- 1.1. The following information is submitted in response to the Rule 8 and 9 letter (TR010065) dated 15th October 2024 for the A46 Newark Bypass submitted by National Highways for an Order Granting Development Consent. Our comments follow the Council's Local Impact Report (REP1-035), Written Representations (REP2-051) and response to ExQ1 (REP2-050).

- 1.3. Having reviewed the information submitted for Deadline 2 (12th November 2024), the Council (as LPA) would wish to comment on submission titled 7.36 Supporting Historic Environment and Visual Impact Assessment (REP2-020). The LPA acknowledges the receipt of information by National Highways at Deadline 2 but does not wish to comment on any matter other than those in this response stated below, which relate to the cumulative effects and the visual impact.

Photomontage 25: Year 1 operation

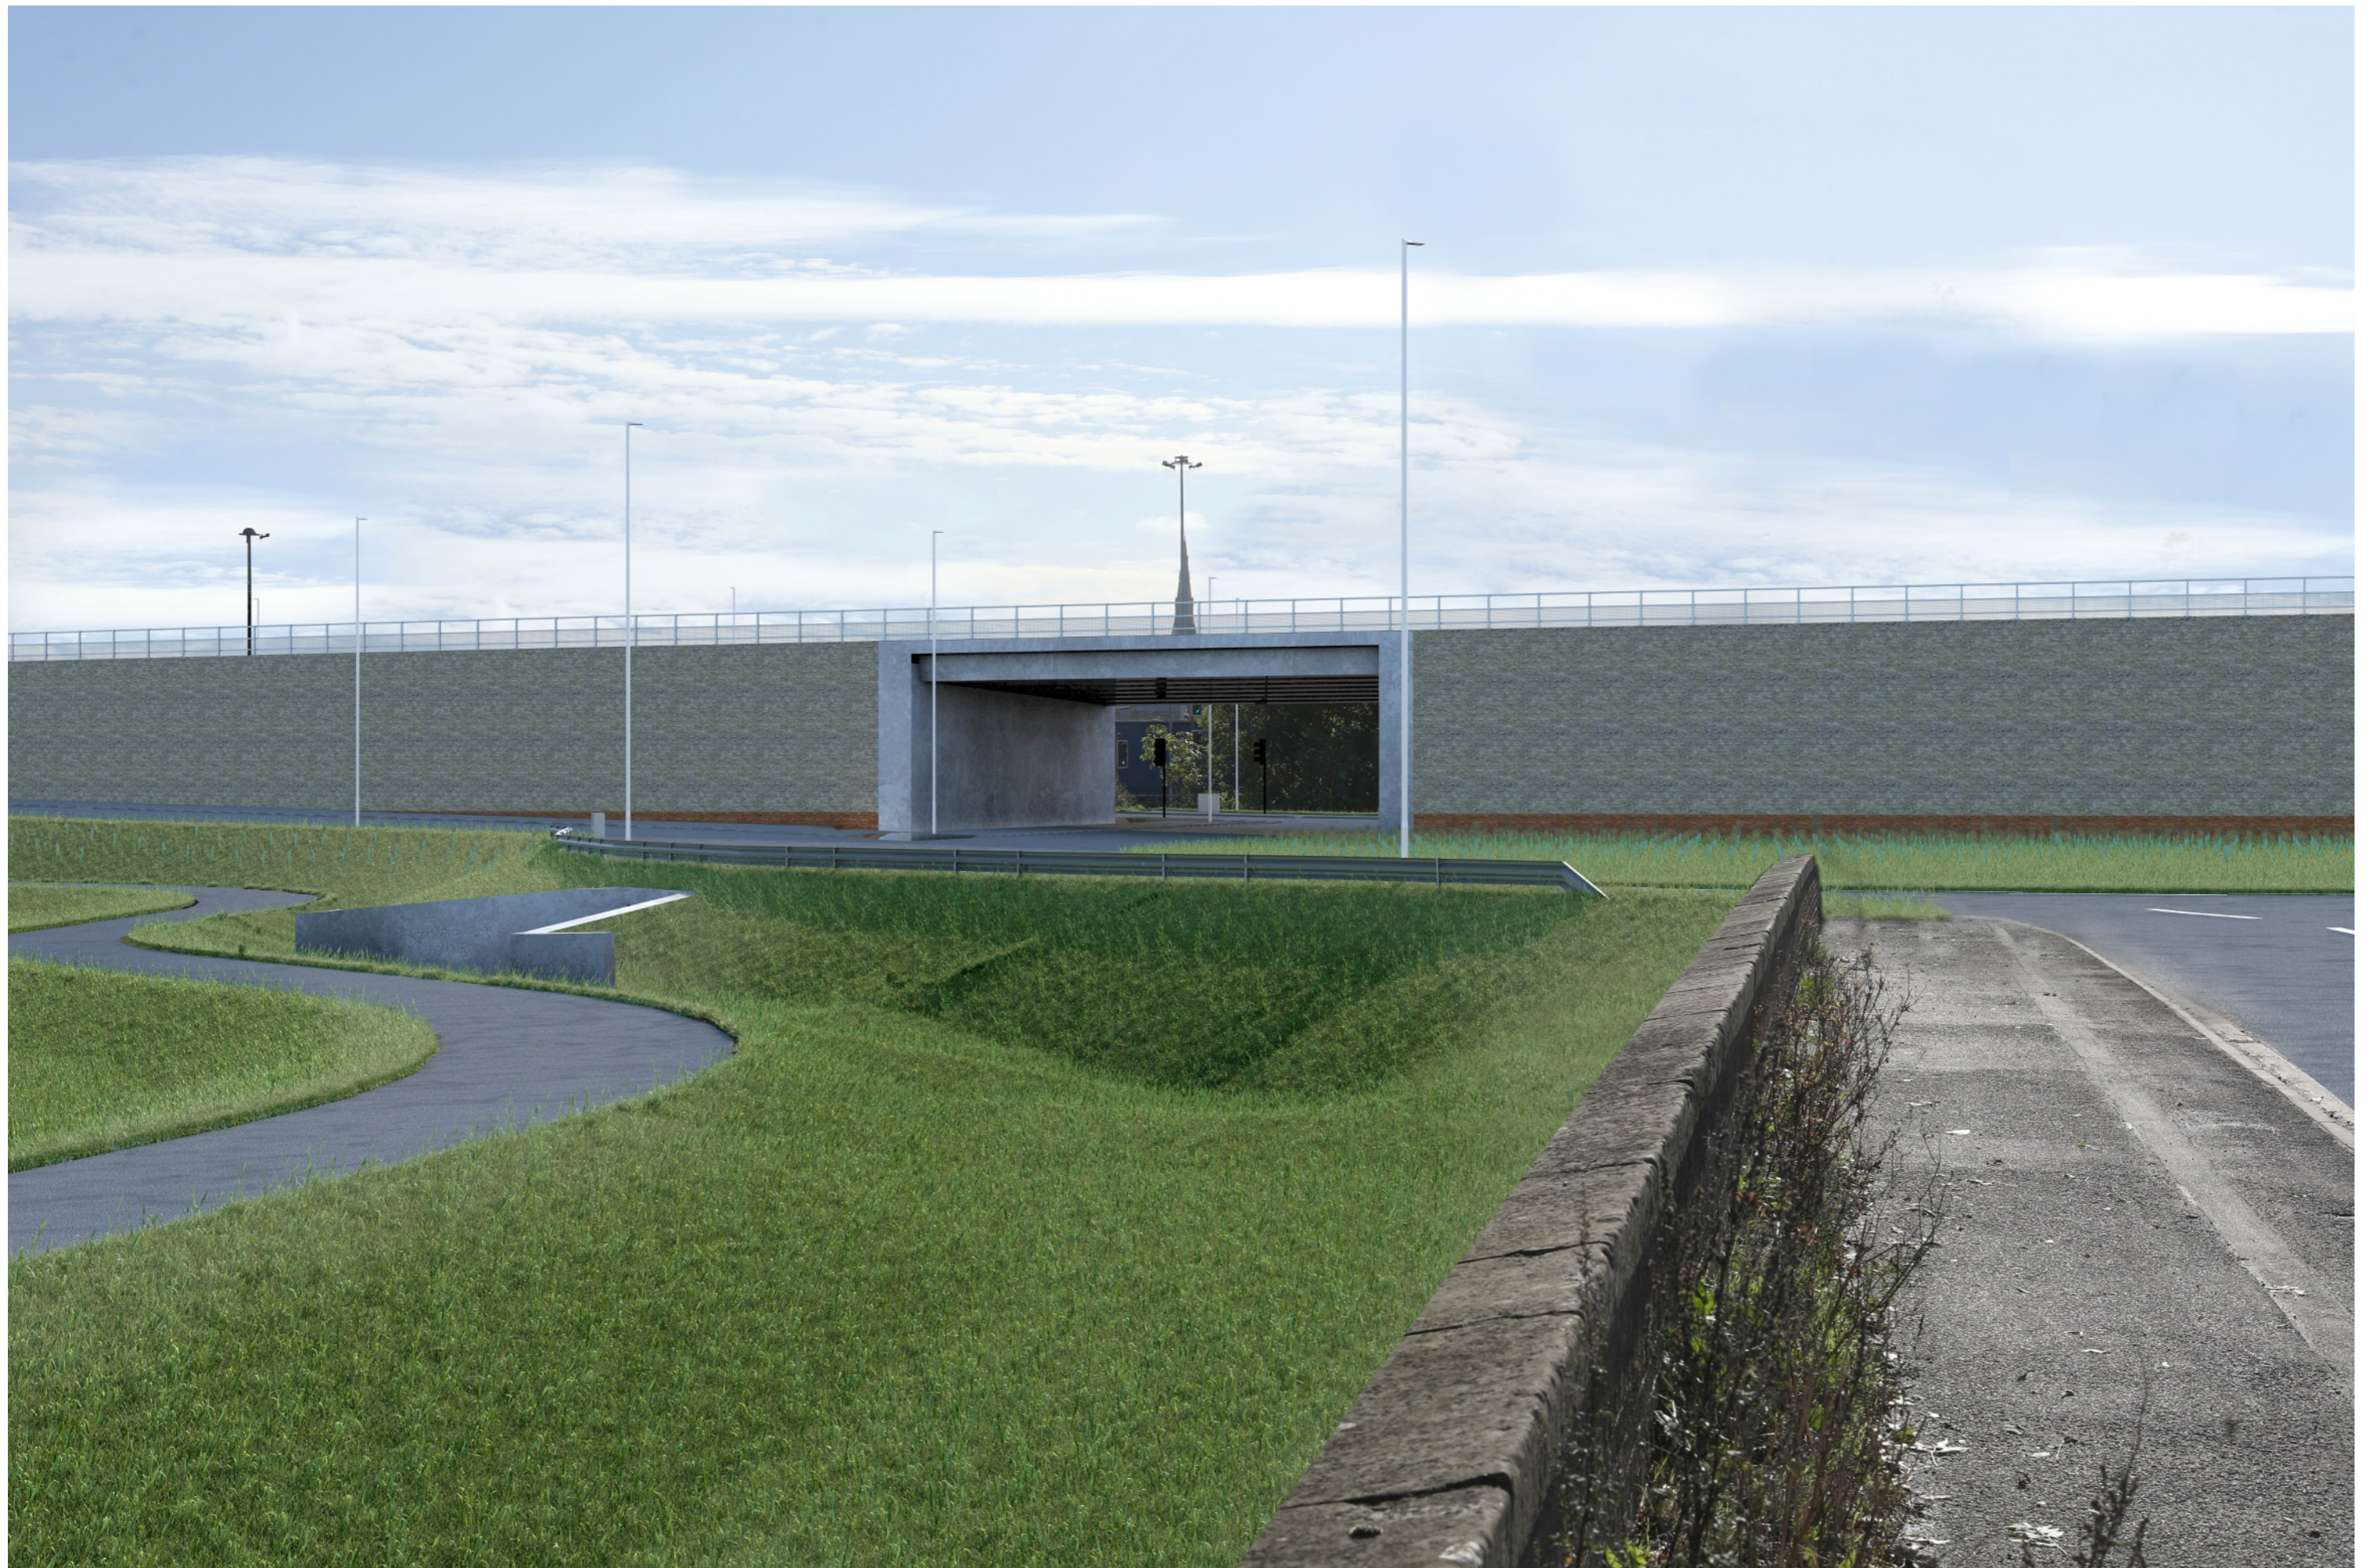
- 3.5. The photomontage doesn't show any light columns on the flyover itself but around the roundabout, it is assumed that lighting will be part of the design, and if they are located on the flyover then these will project even higher. It would be helpful if the applicant could share this lighting scheme or their intentions so we can be more informed of the final design.

- 3.6. The applicant has shown the infrastructure to be flat faced with blank elevations, creating a harsh visual appearance. The current approach to Newark from the north is heavily landscaped on either side of the carriageway with the highway almost seeming secondary to its setting. The spire of Church of St. Mary Magdalene can be viewed from this approach.

3.13. We also wish to bring to the ExA's attention on the accuracy of the photomontage. The photo shows a straight alignment to Smeaton's Arches whereas the General Arrangement drawing Sheet 3 (AS-007) (see extract below) and from discussions with the applicant on the works to Smeaton's Arches and the mitigation proposed, it was agreed that due to the swept path of the roundabout, the arches (above ground) would be on a curved alignment on the approach to the roundabout. This mitigation was discussed in the Council's LIR (REP1-035) and had been taken on board as a proactive approach to the scheme.

3.16. Finally, within the document 7.36 Supporting Historic Environment and Visual Impact Assessment (REP2-020) para 1.3.2, it states *“in order to ensure the photomontage is representative of the view experienced from Great North Road at Smeaton’s Arches, as per the Rule 6 request, the new photograph has been taken further south of VP 25 as denoted in Appendix B of this report.”* From reviewing the photo and the siting of VP25 on the Visual Effects Plan (AS-041) they appear to be in similar locations. The LPA would be interested to understand, by way of a new plotting on the Visual Effects Plan, where this was taken from, as from the photo would appear to be taken from Smeaton’s Arches. Any further south (towards Newark and the Cattle Market roundabout) and the photo would not show the arches.
